KITTITAS COUNTY DEPARTMENT OF PUBLIC WORKS

MEMORANDUM

TO: All Staff
FROM: Public Works Plan Review Team
DATE: May 15, 2024
SUBJECT: BL-24-00004 Lichota

**LICHOTA SITE PLAN
530 ROZA VIEW DRIVE**

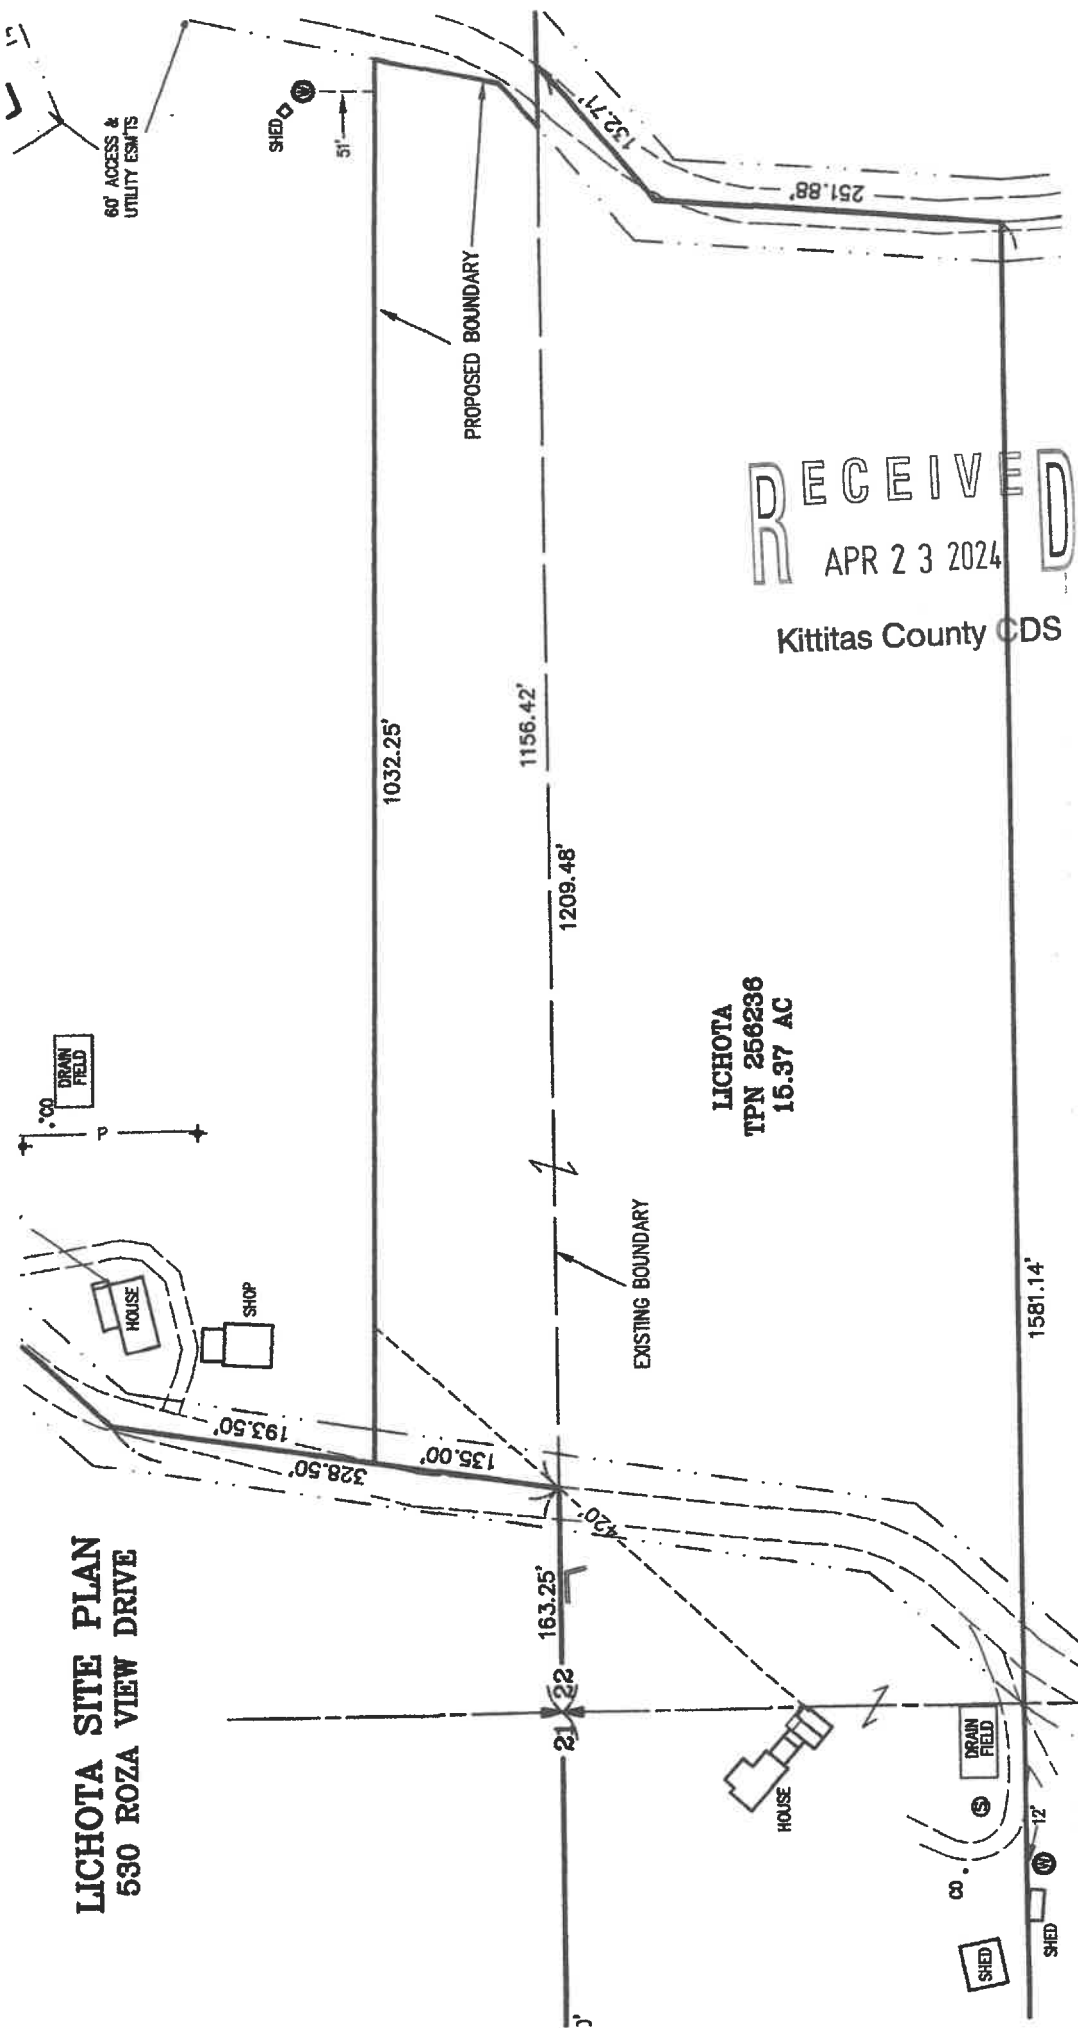
ACCESS	<ol style="list-style-type: none">1. An approved access permit shall be required from the Kittitas County Department of Public Works prior to creating any new driveway access or altering an existing access.2. Maintenance of driveway approaches shall be the responsibility of the owner whose property they serve. The County will not maintain accesses.3. Any further subdivision or lots to be served by proposed access may result in further access requirements. See Kittitas County Road Standards.4. In addition to the above-mentioned conditions, all applicable Kittitas County Road Standards apply to this proposal. Access is not guaranteed to any existing or created parcel on this application. (JS)
ENGINEERING	No Comments. (CC)
SURVEY	<p>As the application does not contain a survey map, comments are herein reserved until final. (JT)</p> <p>UPDATE 06/20/24</p> <ol style="list-style-type: none">1. Please show road name, ownership (Private Ease.), and surfacing for Rosa View Drive. Please label Arrowhead Road.2. Please identify previous boundary line between the subject parcels.3. Show driveways / access roads.4. Please ensure that all markers utilized for survey control include suitable ties on the face of the survey.5. Please ensure the parcel numbers on the map match the lot numbers in the new legal description.
